DEVELOPMENT HEARING OFFICER

PR-2022-007100

SD-2023-00173 – FINAL PLAT

TIERRA WEST, LLC agent **FOR RSF LAND & CATTLE COMPANY LLC** requests the aforementioned action(s) for all or a portion of: **TR MM-1B TRACTS MM-1-A AND MM-1- B** zoned **MX-M**, located at **SEVEN BAR LOOP NW** between **COTTONWOOD DR NW** and **OLD AIRPORT AVE NW** containing approximately **3.7193** acre(s). **(B-14)**

Project No. **PR-2022-007100**

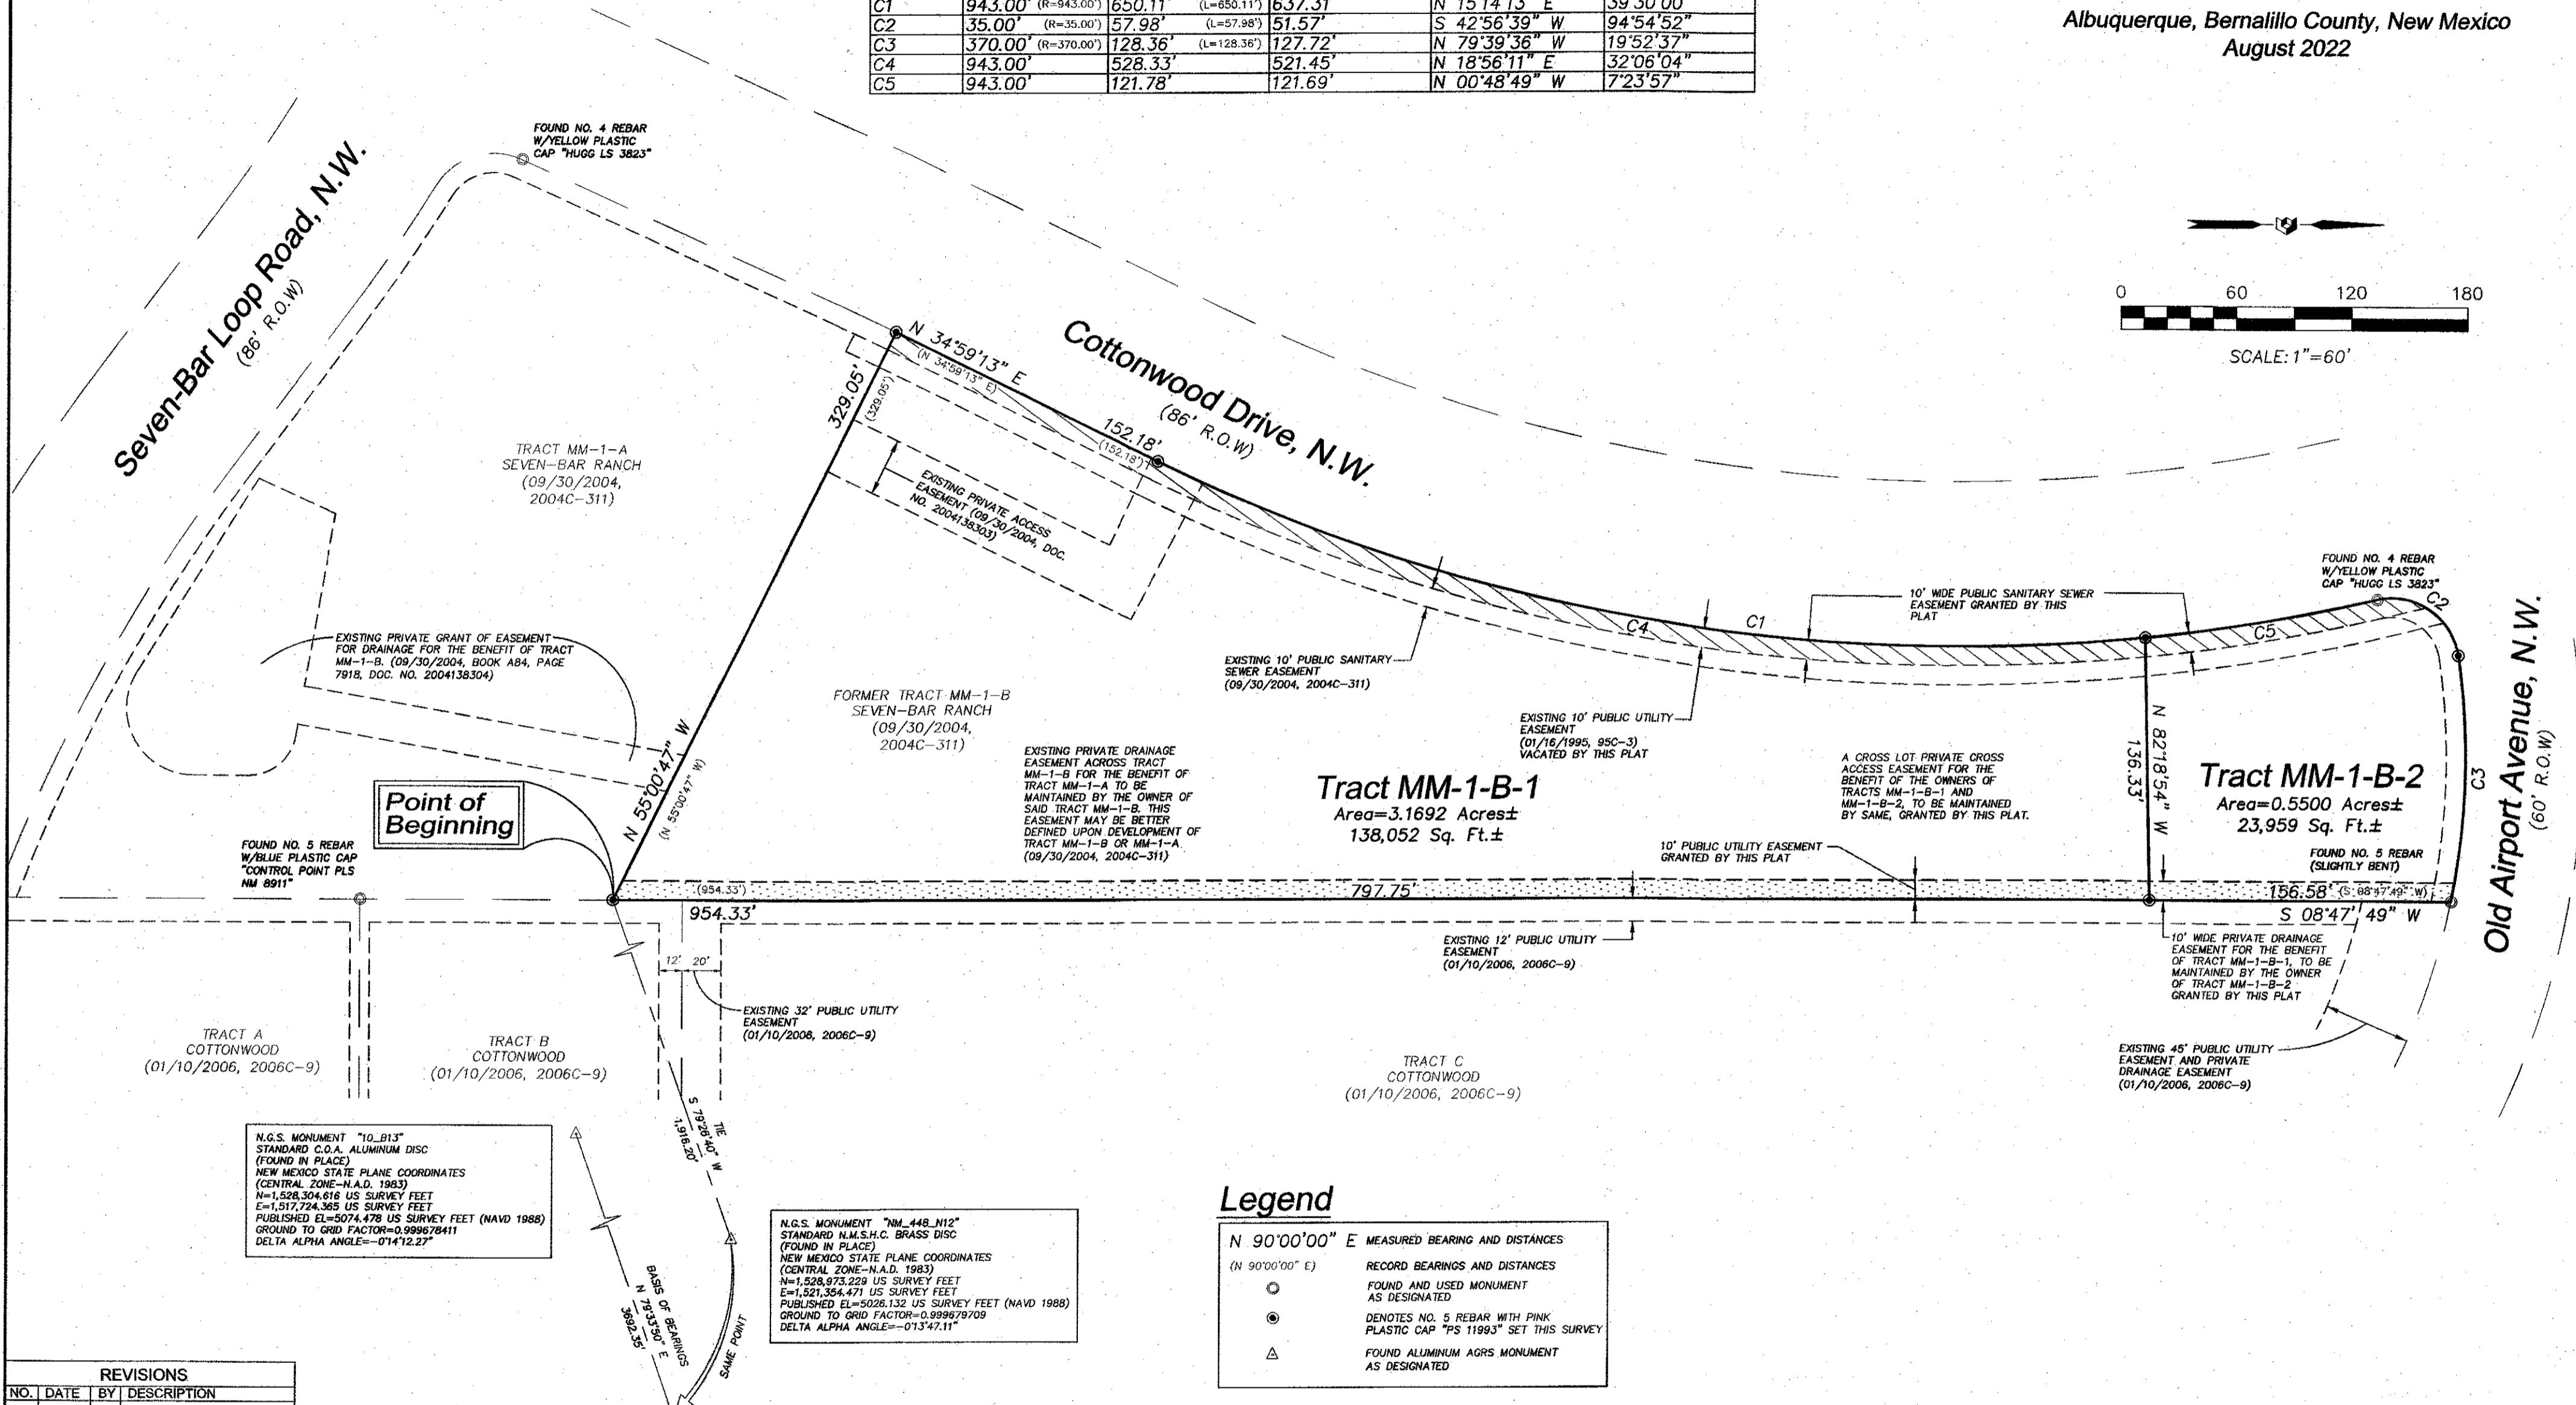
1. Provide additional 10 foot wide sewer line easement east of existing 10 foot wide sewer easement.
Combination public utility/sewer line easement is not acceptable.

- The project number must be corrected to **PR-2022-007100**, and the application number for the Final Plat will need to be corrected to **SD-2023-00173**.
- The DXF file must be approved by AGIS, and the approval email from AGIS must be submitted prior to final sign-off of the Final Plat from Planning should the Final Plat be approved by the DHO.
